KITTITAS COUNTY

TO: All Staff
FROM: Public Works Plan Review Team
DATE: January 10, 2022
SUBJECT: SI-21-00003 Black Horse

The Public Works Department has reviewed the Request for Sign placement and has the following comments:

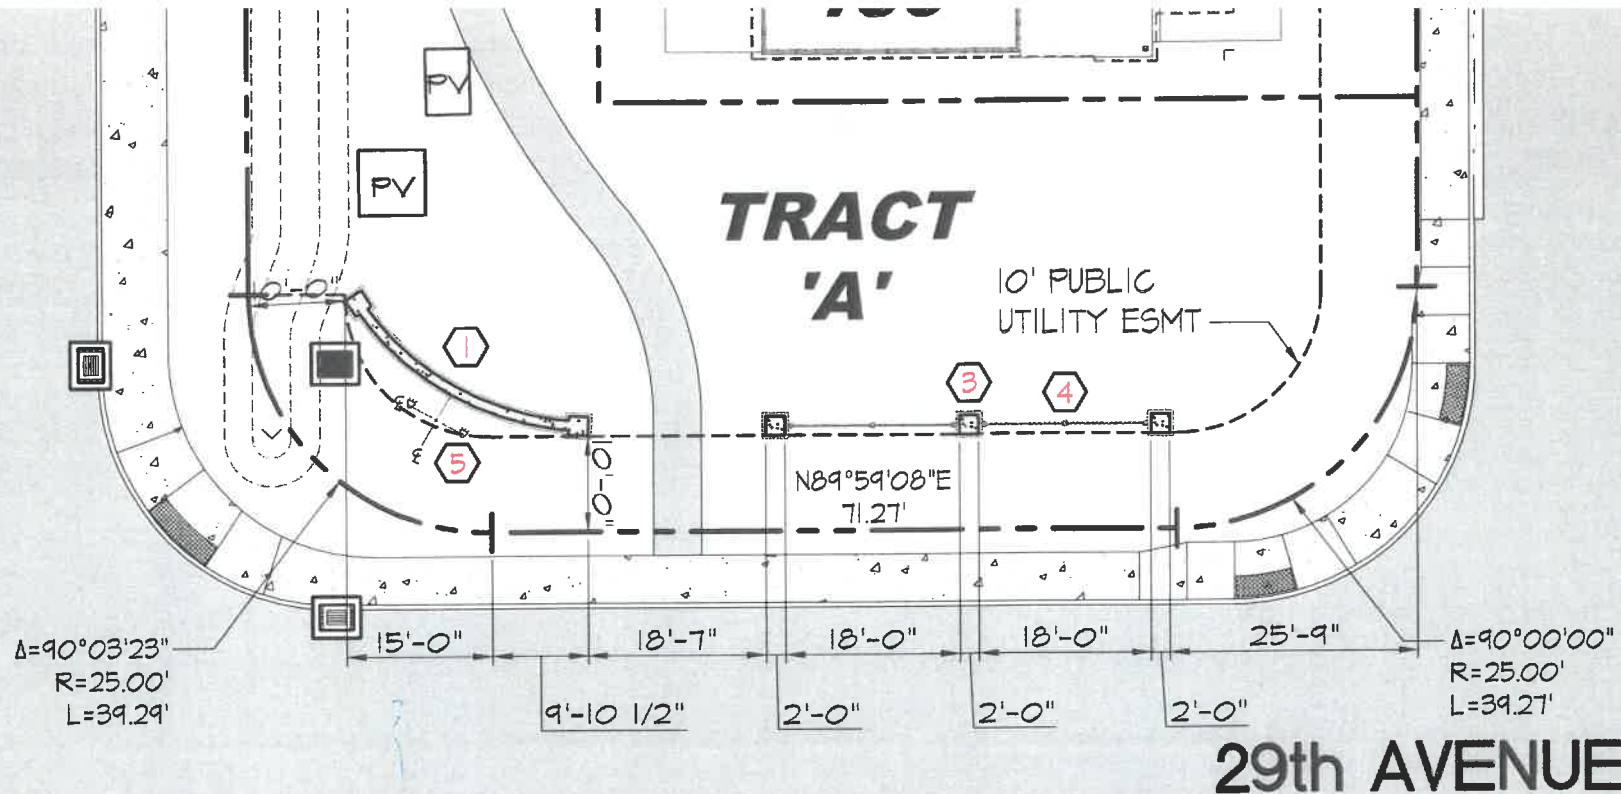
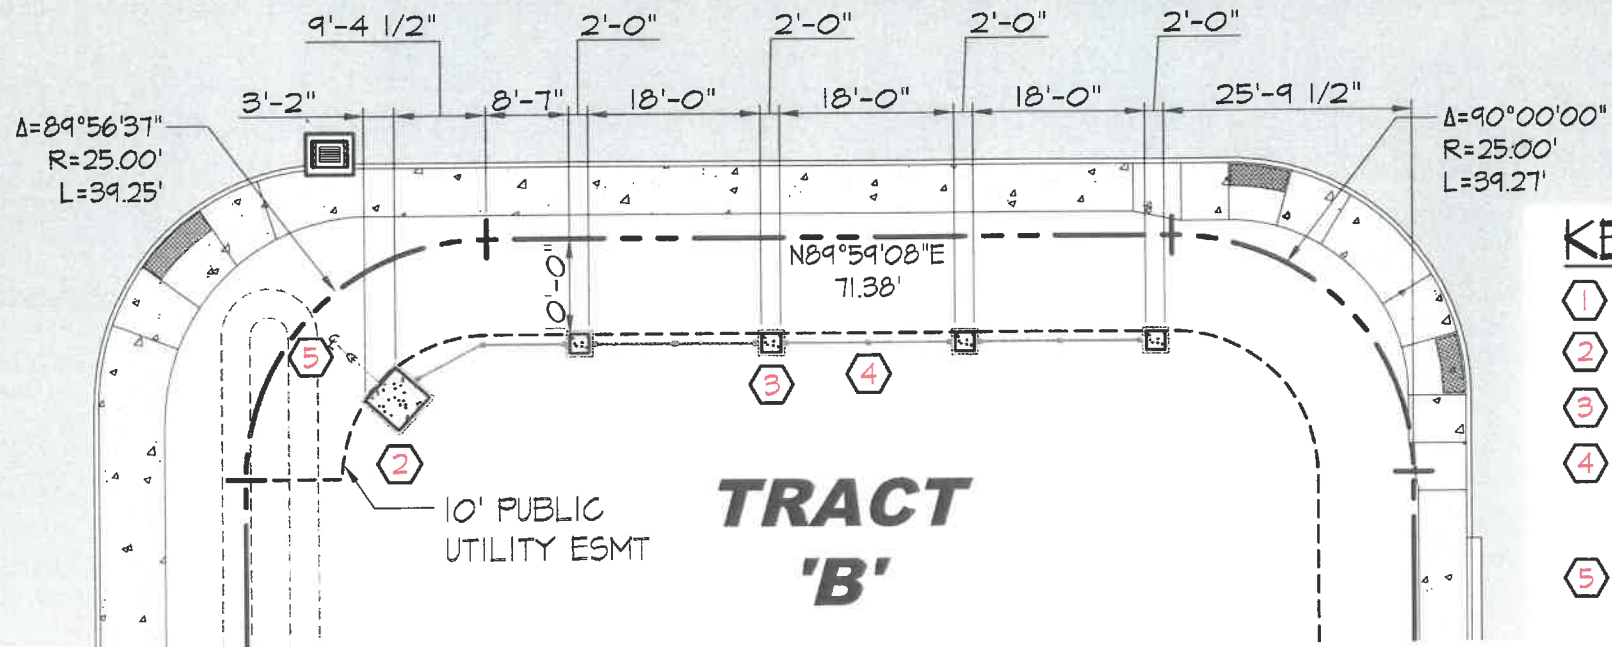
1. Applicant shall not place the sign within the county right of way, access easements, or public utility easements.
2. Applicant shall maintain intersection sight distance triangle as defined by Washington State Department of Transportation (WSDOT).
